Mr Anthony Witherden  
A/Director  
Metropolitan and Regional Projects South  
Department of Planning  
GPO Box 39  
SYDNEY NSW 2001

13 December 2011

**EXHIBITION OF ENVIRONMENTAL ASSESSMENT - PROJECT APPLICATION FOR GRAYTHWAITE REHABILITATION CENTRE, RYDE HOSPITAL (MP1-\_0179)**

Appendix B Car Park Layout

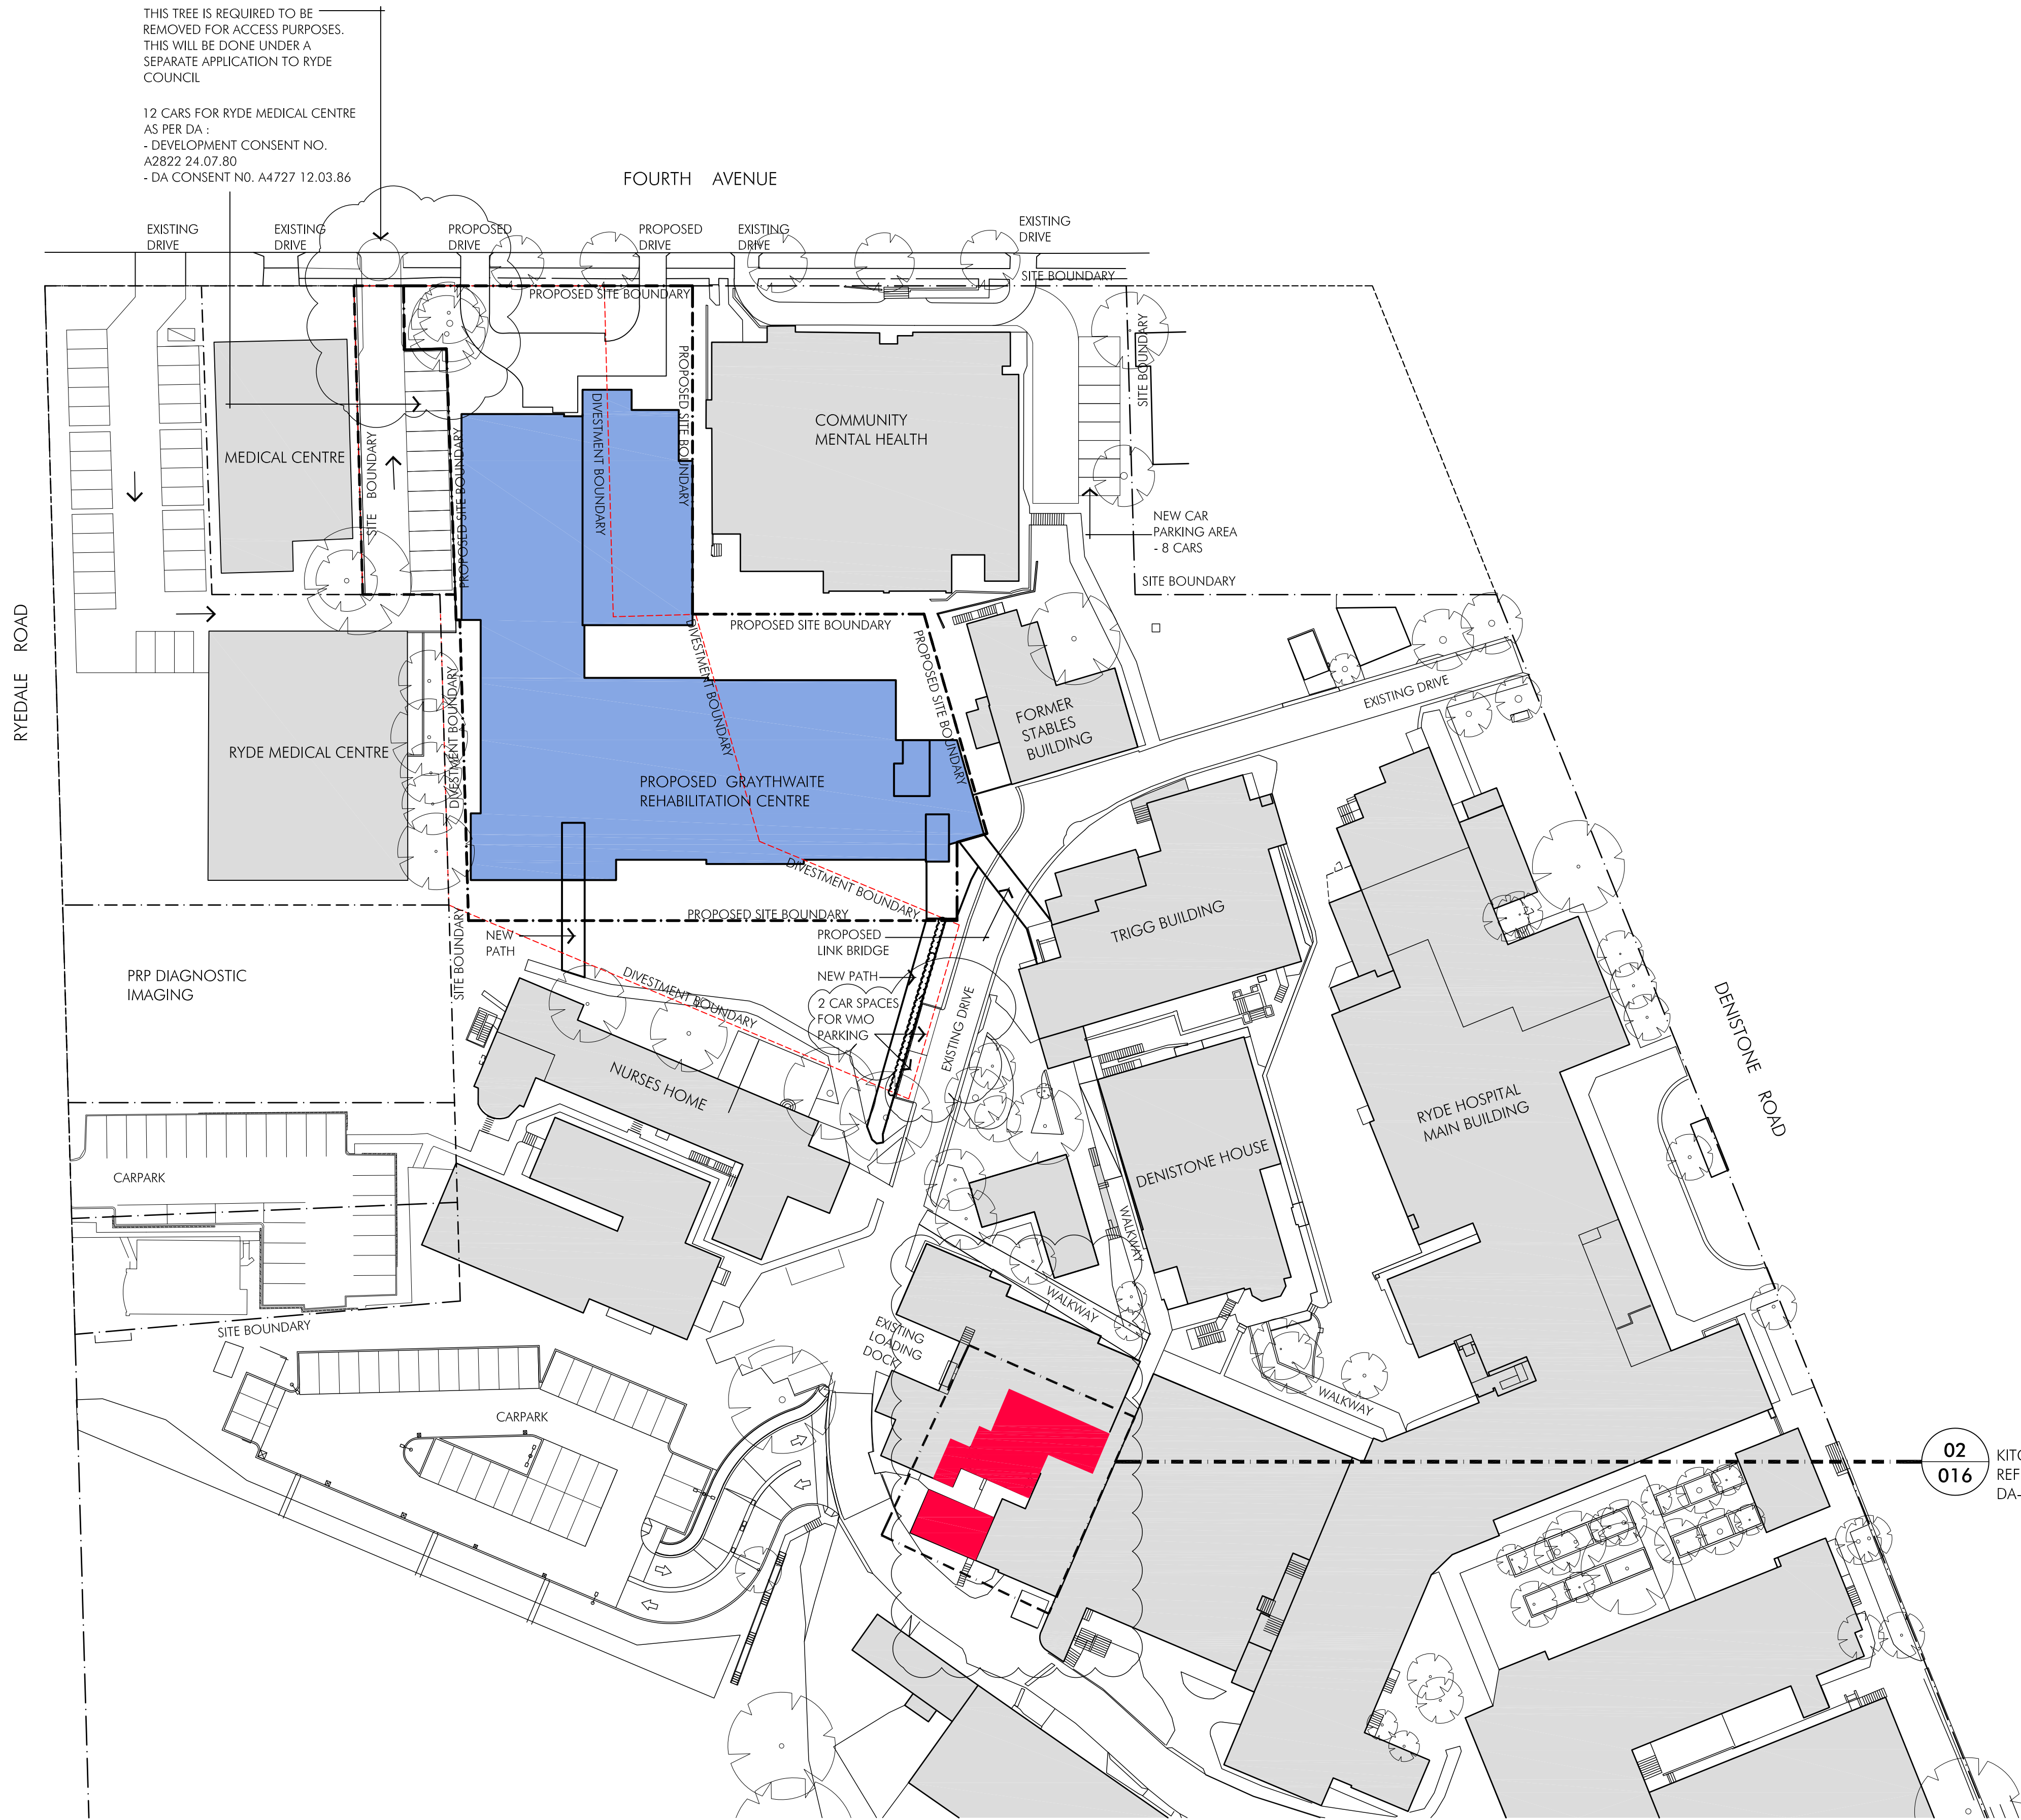
While landscaping and open space have been addressed Council raises concerns with the proposed removal of a Council street tree. Any such removal needs the consent of Council.
